Our Case Number: ACP-323606-25

An
Coimisiún
Pleanála

Date: 11 March 2026

Re: Proposed construction of 67 no. housing units
on a site at Tyrells Land, situated along Stradbally Road, Portlaoise, Co Laois

Figure 1-2 Site Layout

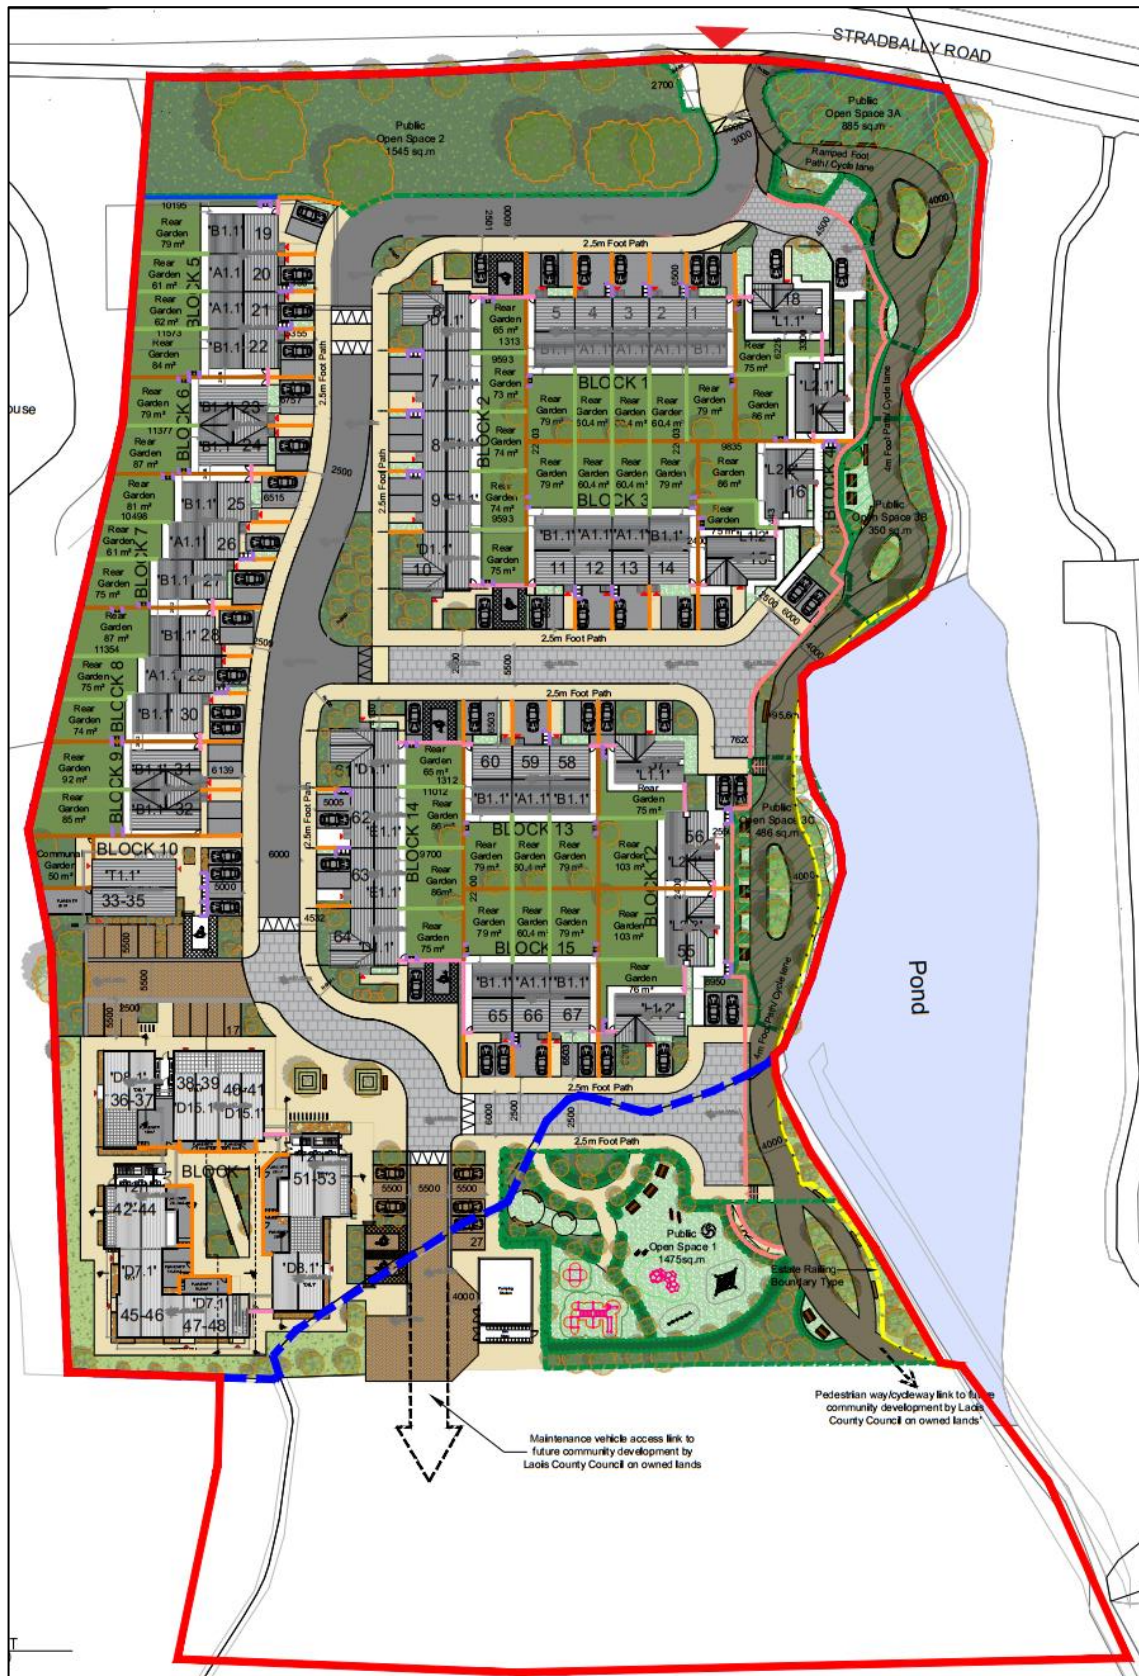
Please address the concerns raised by IFI with respect to the assessment of flood risk and site drainage. Please provide a revised or addendum FRA as necessary, to include clarifications on conclusions reached with respect to the location of the site and the flood plain; the effective operation of surface water management features on the site; and run-off calculations.
